CITY OF ALBUQUERQUE

September 19, 2023

Albuquerque Public Schools (APS) –
APS Director of Construction, Karen Alared AIA alarid_k@aps.edu
APS Cluster Technician, Rita Romero rita.romero@aps.edu
Site: APS Arroyo Del Oso Elementary School (10 Ac.)
3831 Harper 9717 Indian School Blvd NE
(H20E028) - NMR1005UE

Re: Drainage Ordinance (14-5-2-11) Violations for Erosion and Sediment Control

C.102

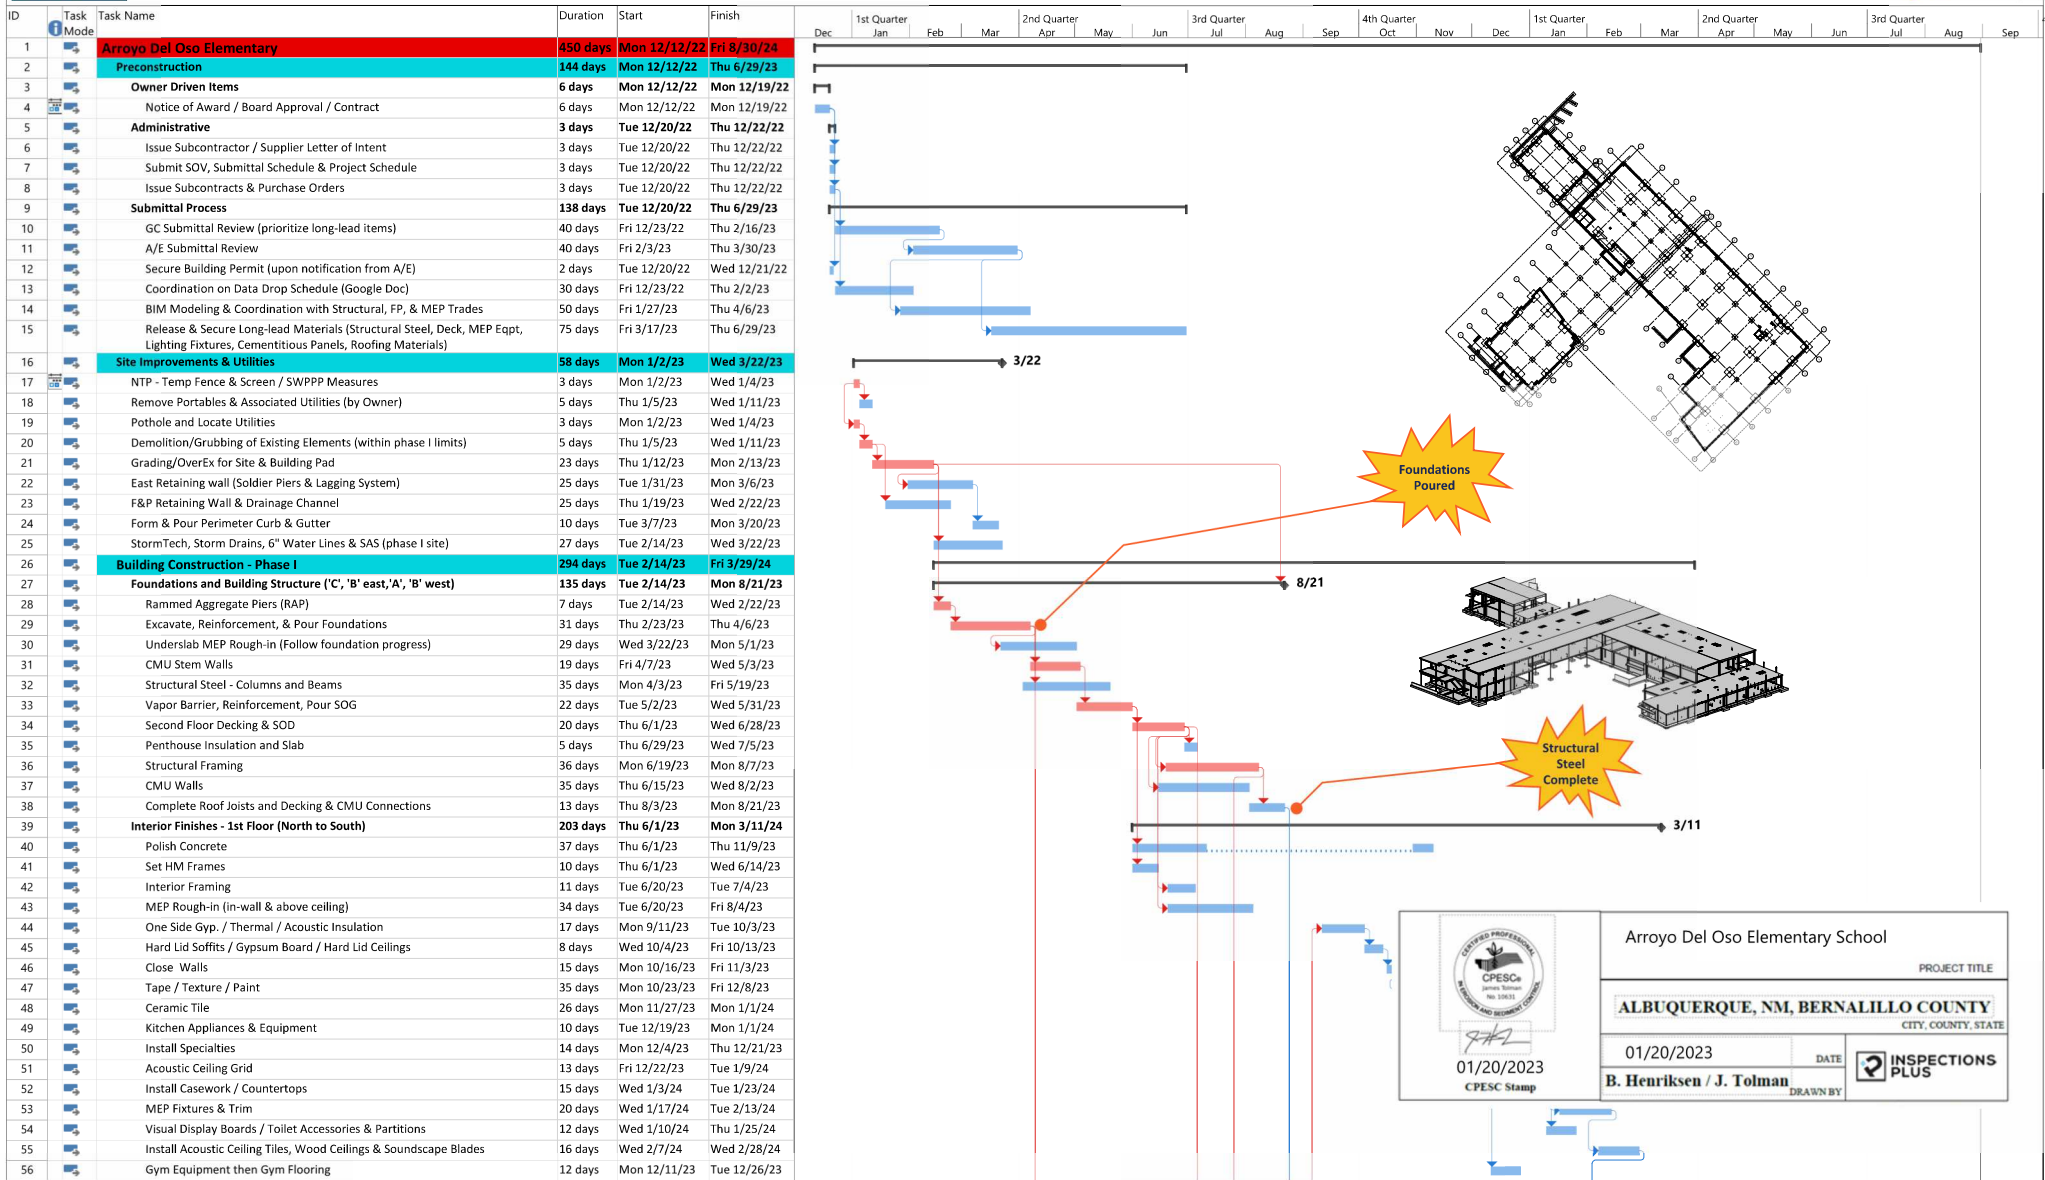
3. **BMPs** – The 14,593 cf permanent underground retention pond is less than half the size of the temporary pond required for this 10 acre site per CGP 2.2.11.C.ii. (3,600 cf/ac). There was no apparent way for drainage to get

into the temporary pond at the time of inspection. Perhaps stormwater can infiltrate slowly through the top, but it is situated out of the flow path of surface drainage allowing a large portion of the site to bypass the pond.

The diversion of the offsite 15 acres to Lafving St. is incomplete, and the temporary diversion with silt fence and dirt appears to be inadequate.

The temporary pond size would need to be increased to 90,000 cf to include the offsite area per CGP 2.2.11.C.ii if the diversion fails like it did on 8/8/23 and the 15 acre offsite runoff is added to the 10 acre onsite runoff.

3. **BMPs** – Provide a pond sized in accordance with CGP 2.11.c in a location that intercepts all potential stormwater runoff and a non-erosive temporary diversion. Ensure that all stormwater controls (BMPs) are maintained and remain in effective operating condition during permit coverage per CGP 2.1.4. If at any time you find that a stormwater control needs routine Maintenance, you must immediately initiate the needed maintenance work and complete such work by the close of the next business day. When the problem requires a new or replacement control or significant repair, install the new or modified control and make it operational, or complete the repair, by no later than seven (7) calendar days from the time of discovery per CGP 5.2.1.
